DOC21/426604-04; EF13/3037

EPA Advice on Response to Submissions Report

Thank you for the request for advice from Public Authority Consultation (SSD-7293), requesting the review by the NSW Environment Protection Authority (EPA) of the Submissions Report for the proposed Sancrox Quarry Expansion Project (Application SSD-7293) at Sancrox Rd, Wauchope.

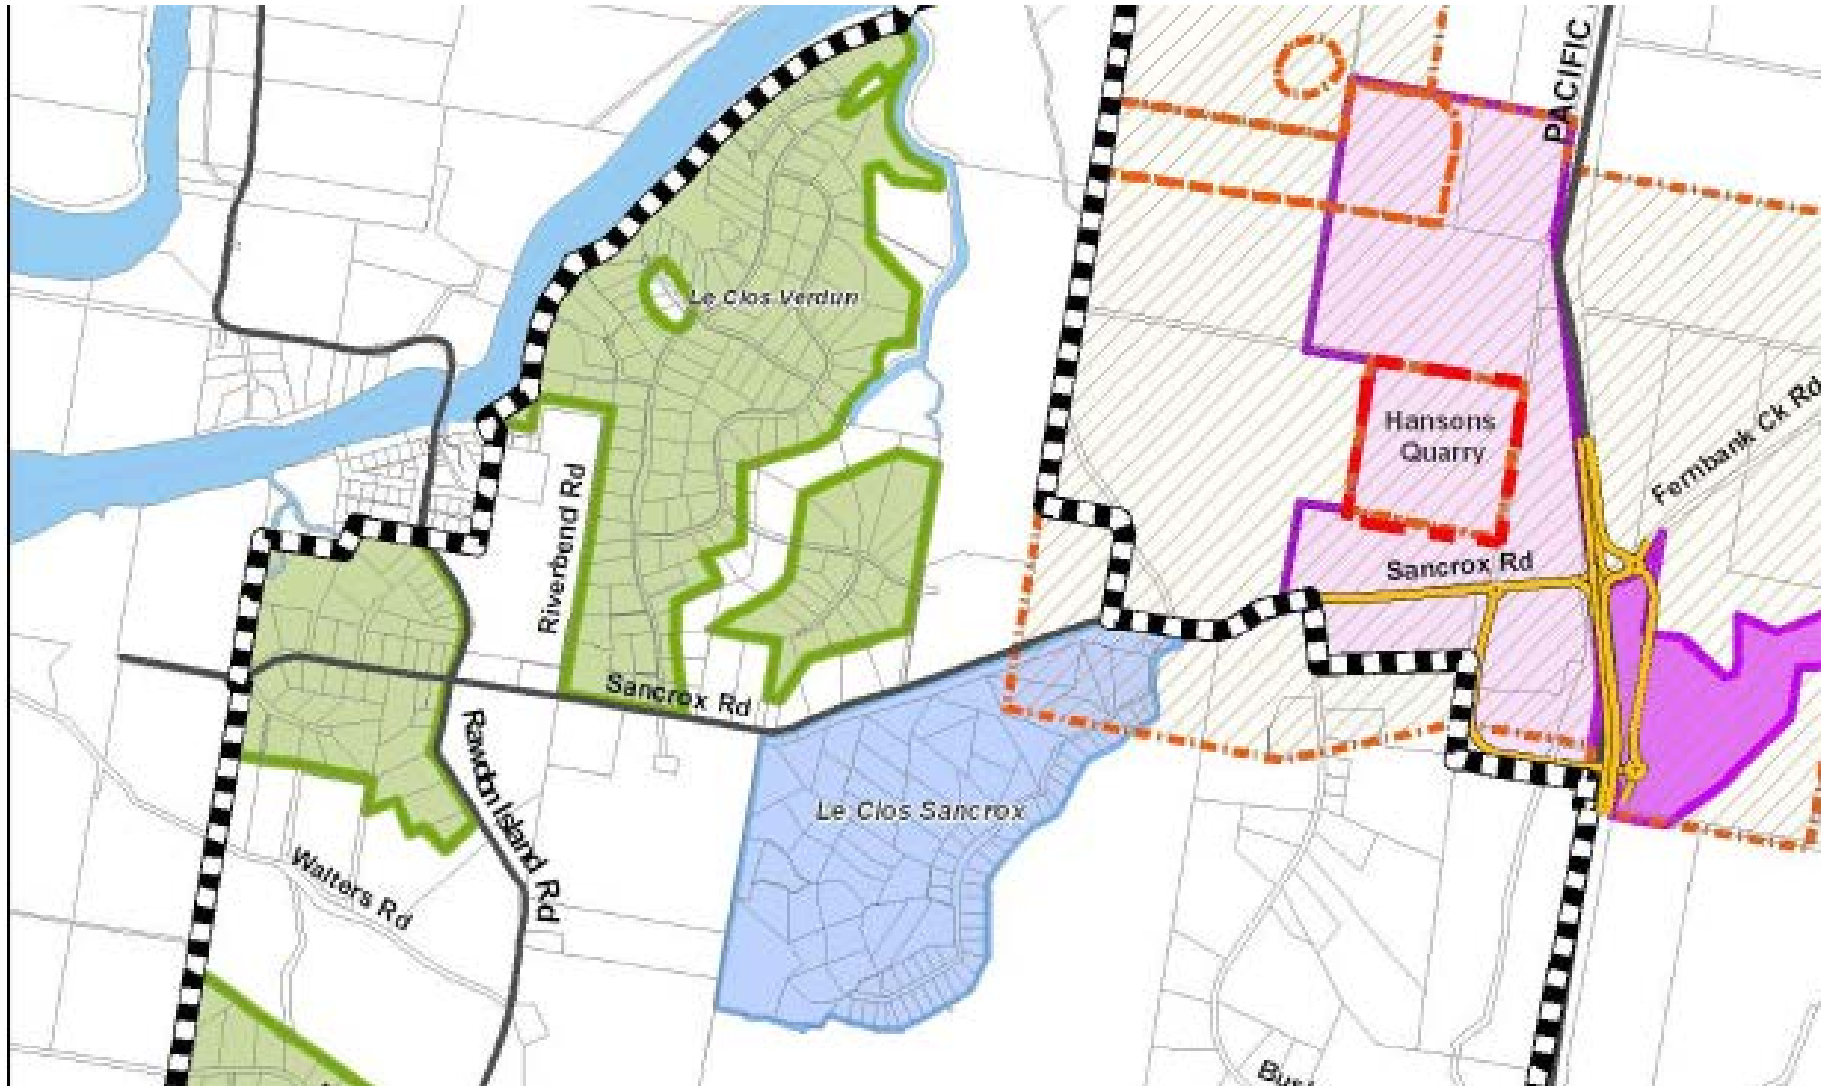
- Predicted cumulative impacts have not been presented at the adjacent area located to the east of the project boundary. Whilst it is acknowledged that future sensitive residential receptors will be located further afield from receptors identified in the AQIA, as noted in Figure F2.1 in the EIS¹, the area located to the east of the project boundary is an approved industrial area. Thus, and in accordance with the Approved Methods for the Modelling and Assessment of Air Pollutants in NSW (The Approved Methods), the potential impact at these locations should be assessed.

Air Quality – Annual Mean Cumulative PM₁₀

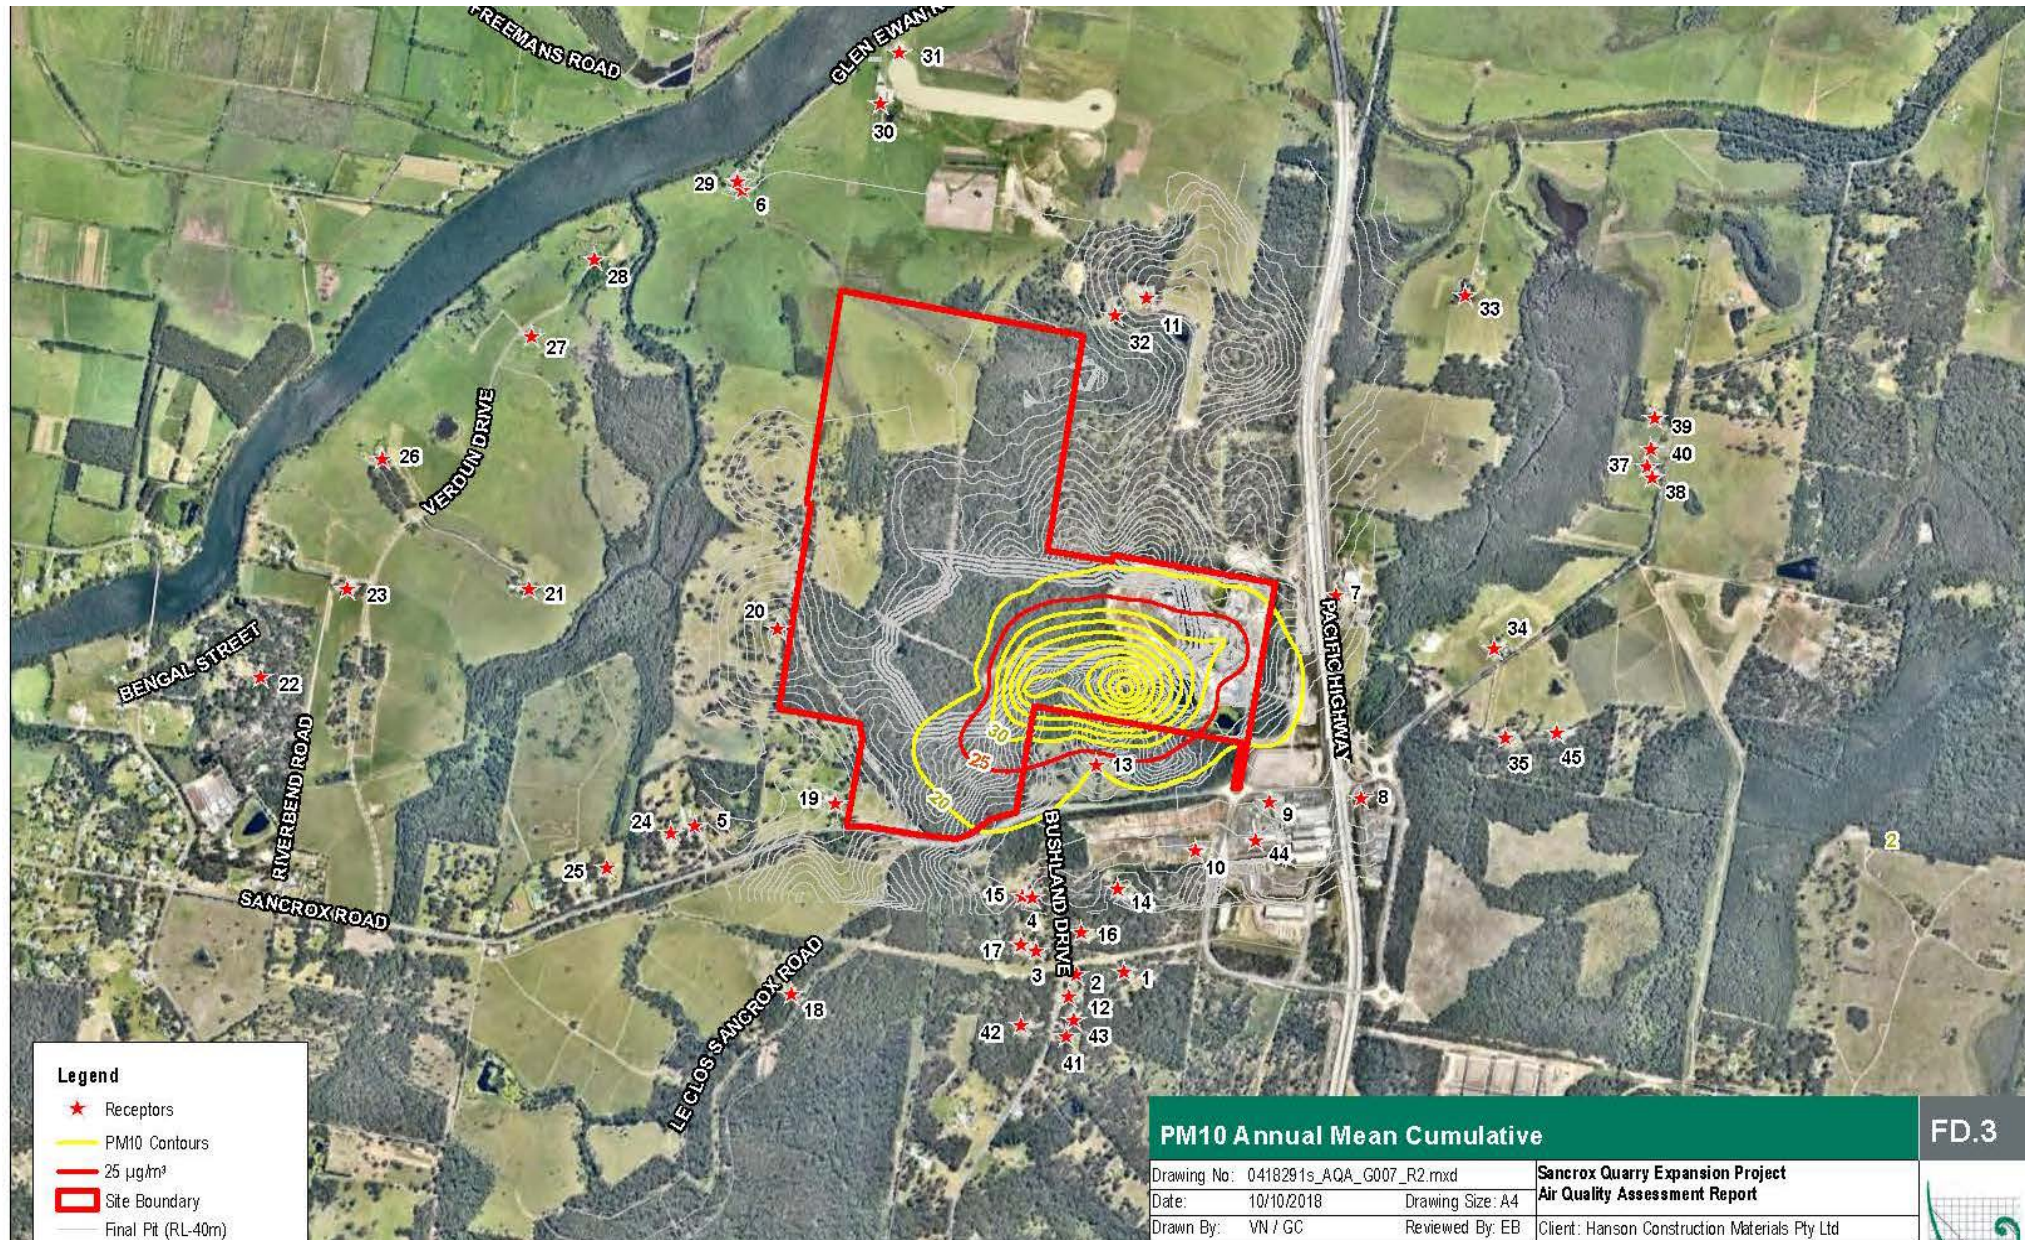
It should also be noted that the annual average PM₁₀ contour plots presented in Appendix C (Figure FC.2) in the revised AQIA show significant predicted impacts in this area, including potential exceedances of the annual average PM₁₀ impact assessment criteria. Further it is noted that Figure FC.2 does not appear to align with the predicted results in Table 7-1.

Additionally, the contour plots should be reviewed and revised where appropriate, given the discrepancies with tabulated results.
